DECISION DELEGATED TO DEVELOPMENT MANAGER

Application No: H16-0076-20 **Applicant:** Mrs Amanda Stoffel

Proposal: Two-storey extension to the side of the existing property creating a large kitchen diner downstairs and a bedroom and en-suite upstairs

Location: 3 Charlette Way Spalding

PROPOSED ELEVATION PLANS (1:100)

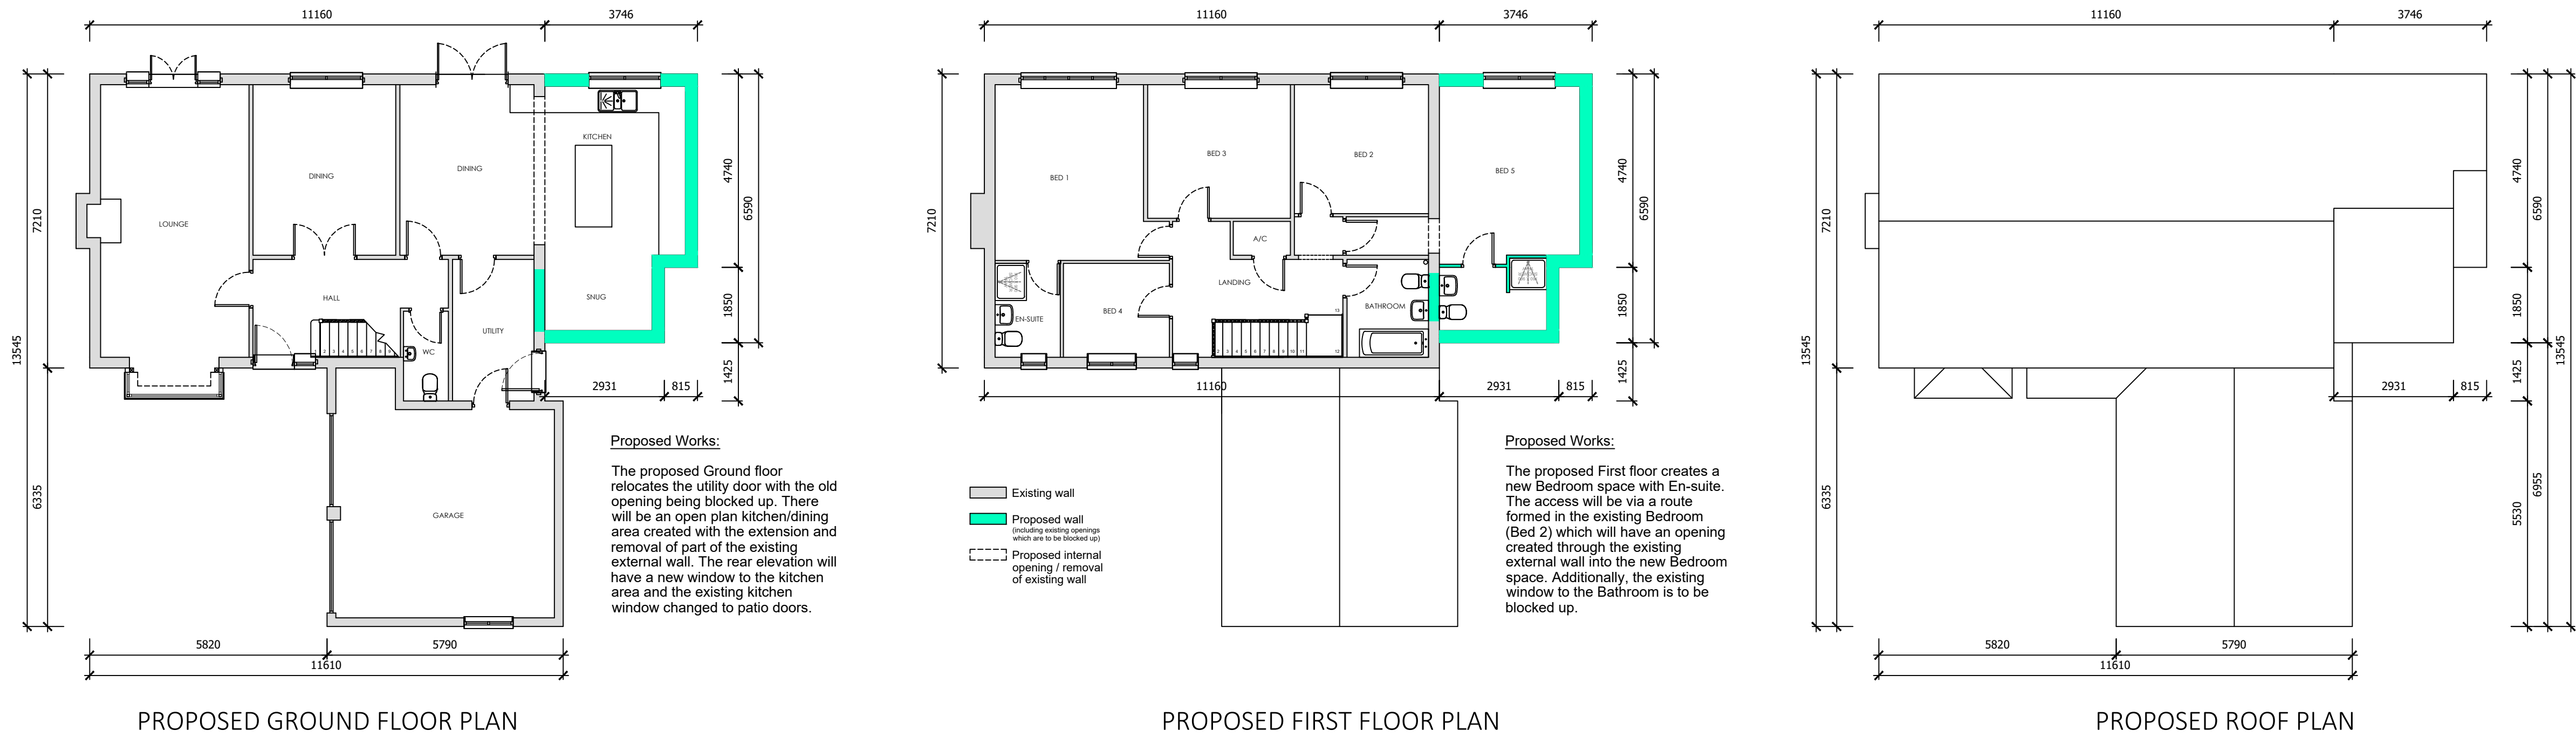
The only fenestration proposed is to the rear of the extension, therefore the front elevation is blank. The majority of windows on the front elevation as existing are confined to the eastern side so the opposite side of the house would appear even more dominated by brickwork. However, because the property is set back and views of the extension would largely be obscured by the neighbouring property's and host property's garages, it is not considered that this in itself would warrant a reason for refusal.

The proposed extension would be approx. 80cm from the boundary with the neighbouring property at its closest point and would effectively be a large blank wall. The existing separation distance between the property and the rear garden of the neighbouring property is approximately 3.8m. There is therefore also a concern that a two-storey extension would be overbearing in nature for the occupants of the neighbouring property and enjoyment of their garden could be unduly affected.

With regard to privacy, there are no windows proposed at first floor on either the front or side elevations so there should be no issues of overlooking the neighbouring property to the west. There would be approximately 15m between the rear facing elevation windows of the extension and those of existing properties to the south. However, the angle of the windows mean that overlooking in that direction is not a significant concern.

PROPOSED SITE PLAN (1:200)

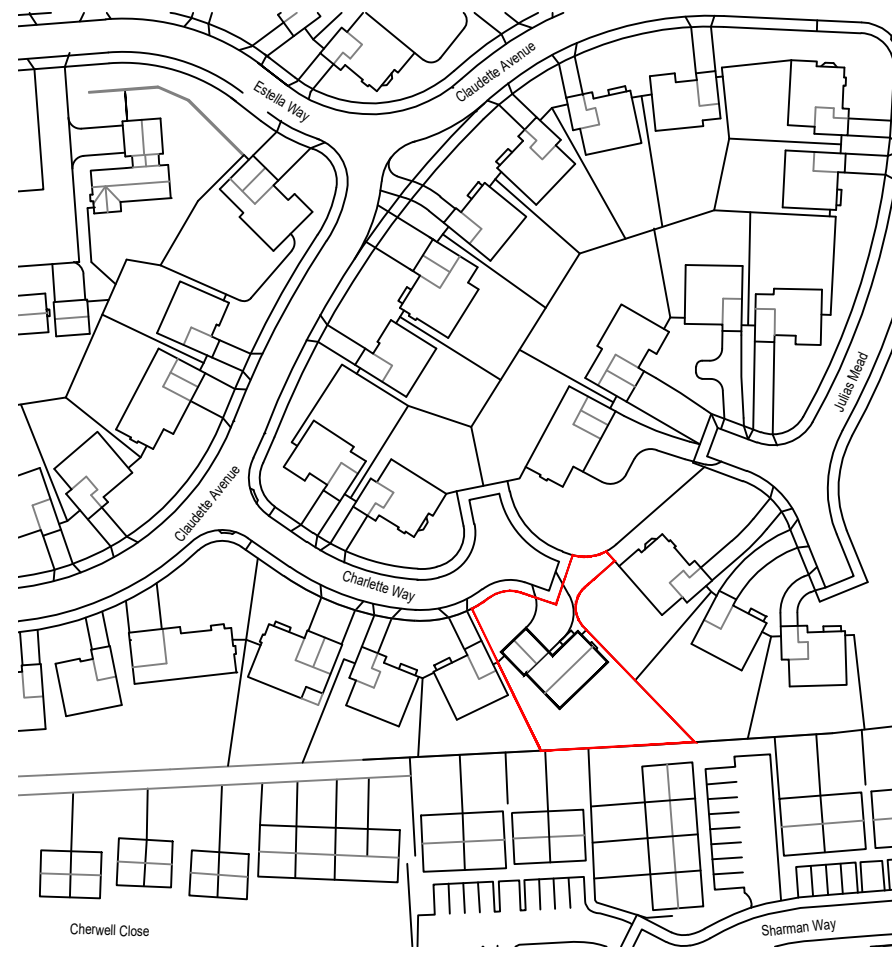
The extension would be approx. 80cm from the adjoining boundary with 4 Charlette Way at its closest point. Due to the angle and positioning of the properties, the extension would almost entirely be to the rear of the neighbouring property and therefore adjacent to their rear garden.

Due to the angle and positioning of 3 and 4 Charlette Way, the proposed extension would almost entirely be to the rear of the neighbouring property and would therefore also be adjacent to their rear garden.

After conducting a 45 degree BRE daylight/sunlight loss test on the plans provided, it has been concluded that more detailed tests are required due to the potential for loss of light to the dining room of the neighbouring property.
